HOMESTEAD NORTH INTERSECTION SPACING

INTERSECTION SPACING
HOMESTEAD NORTH
JOB NO. 25188.00
03-02-2021
SHEET 1 OF 1

EXHIBIT A

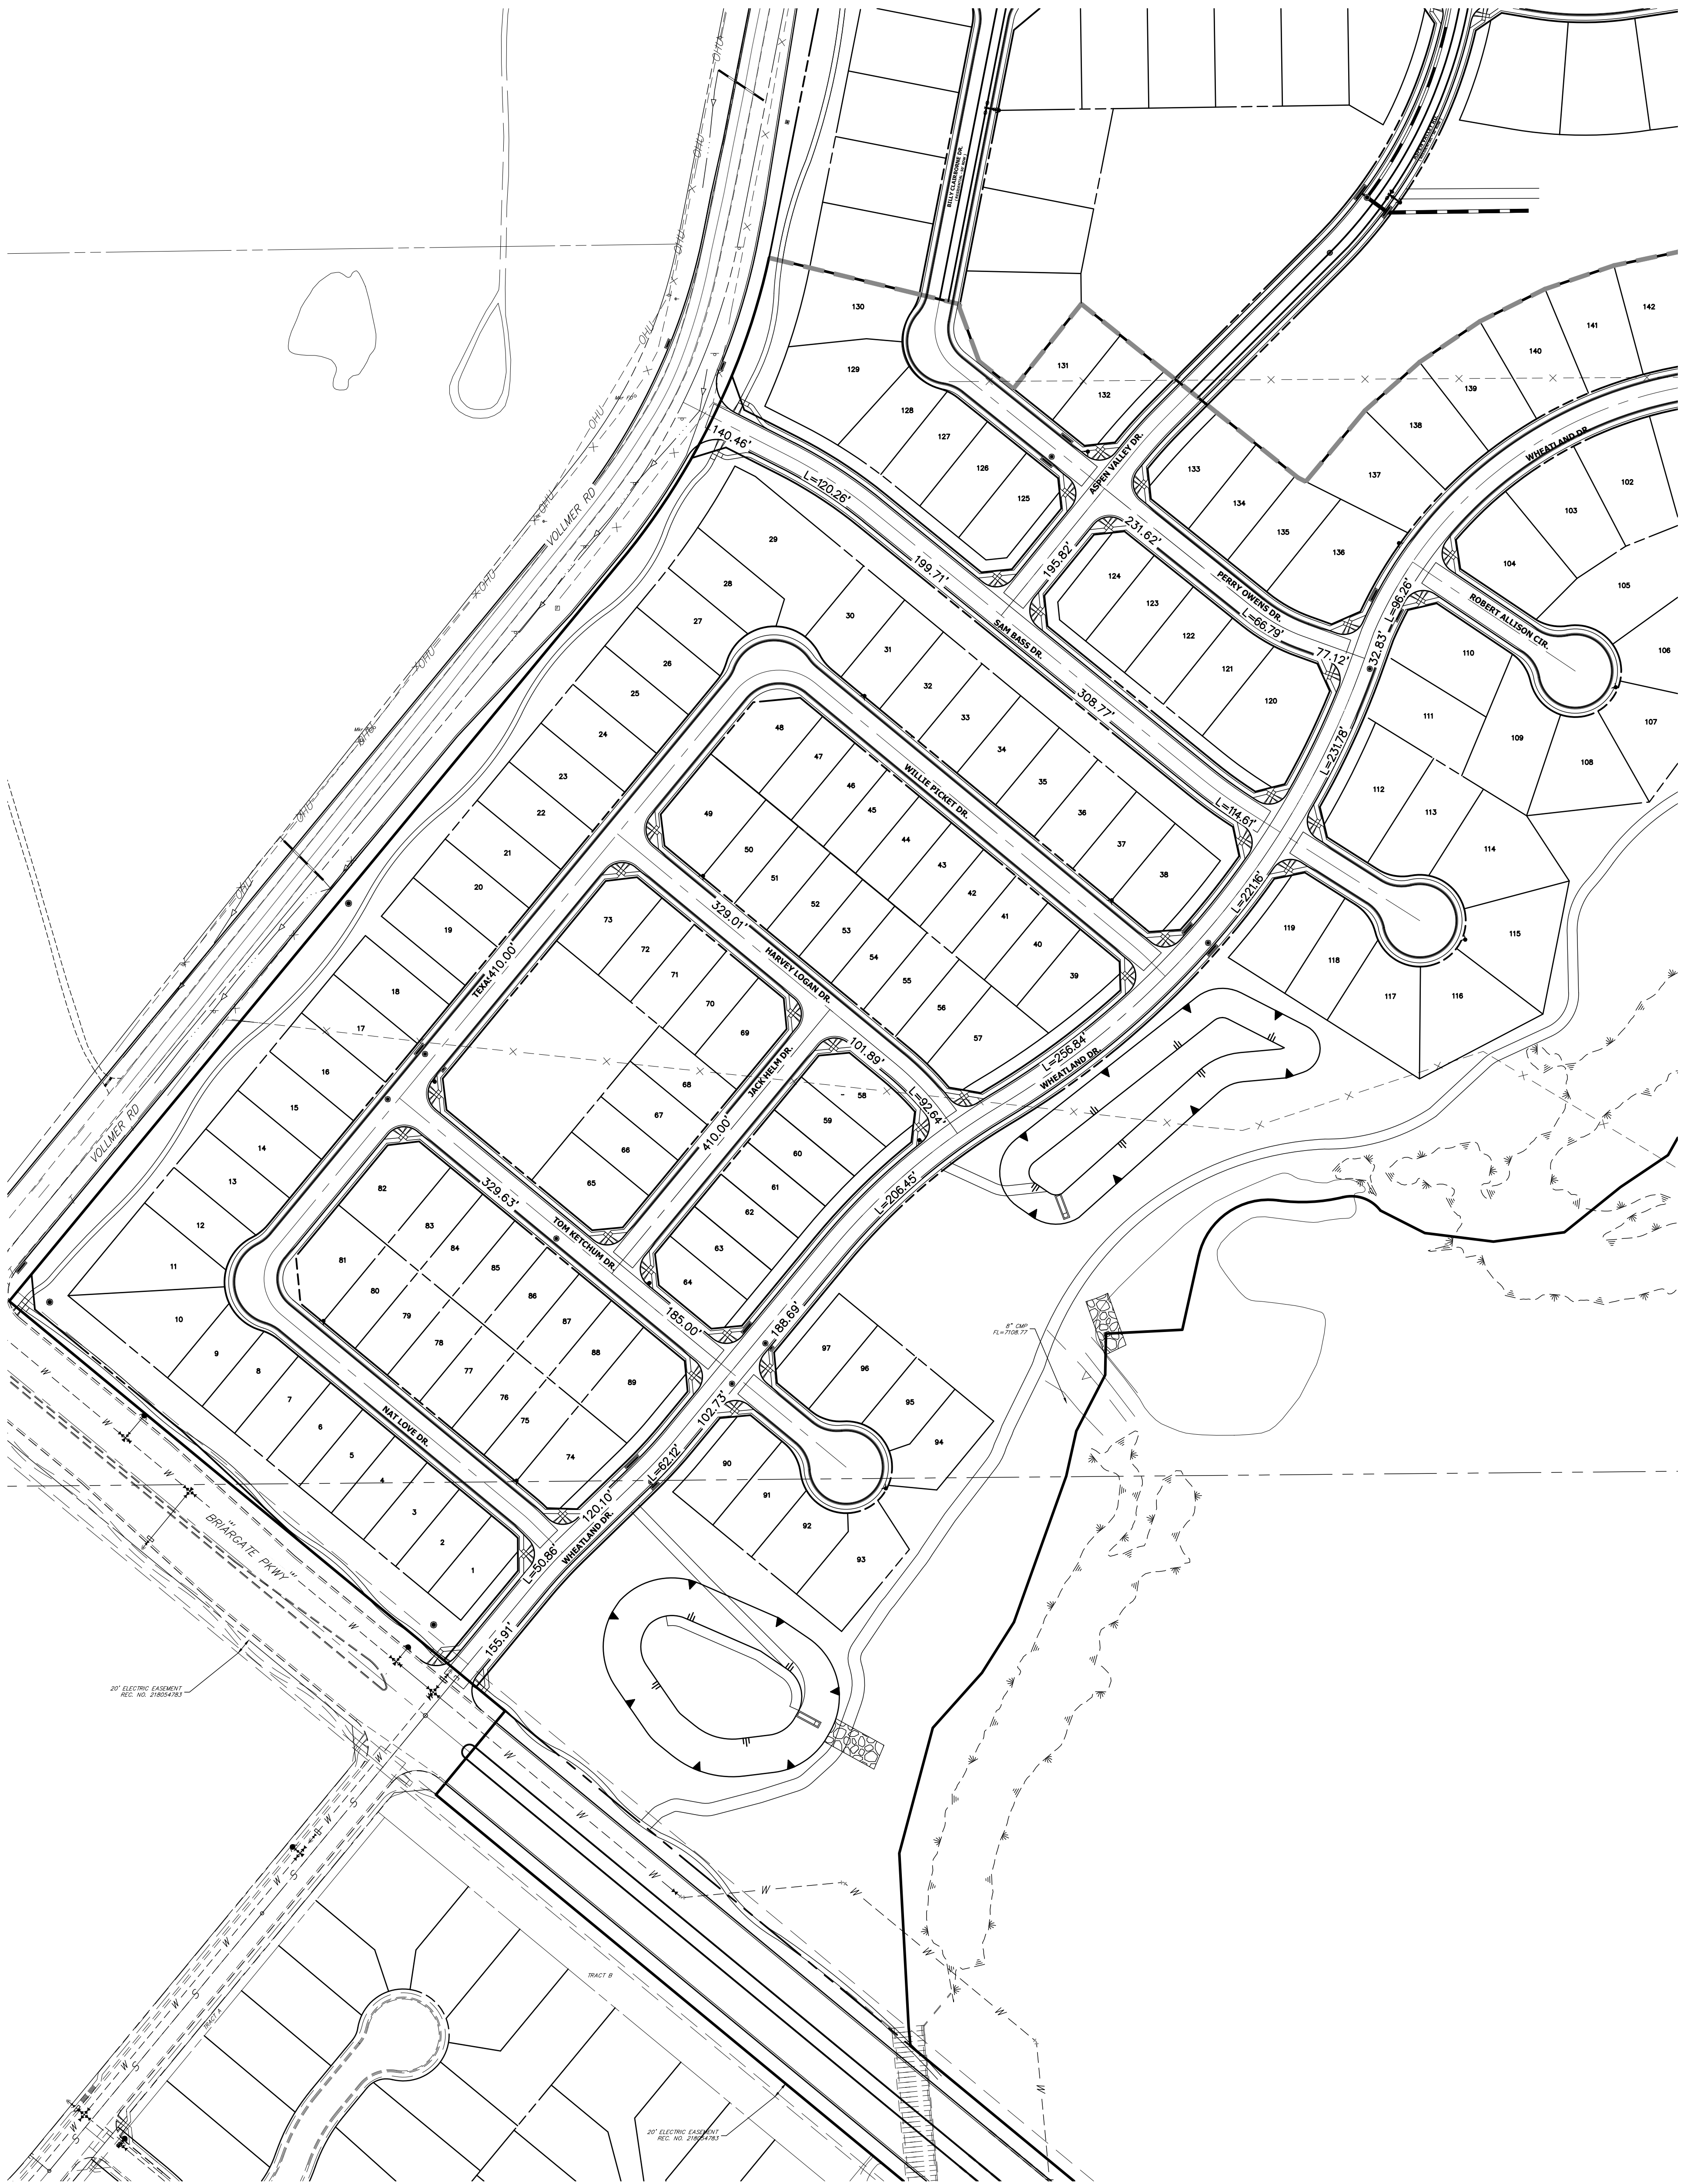
Call out the subject deviation area.

Provide sight distance lines at the two intersections

JR Response: Addressed

JR Response: Addressed
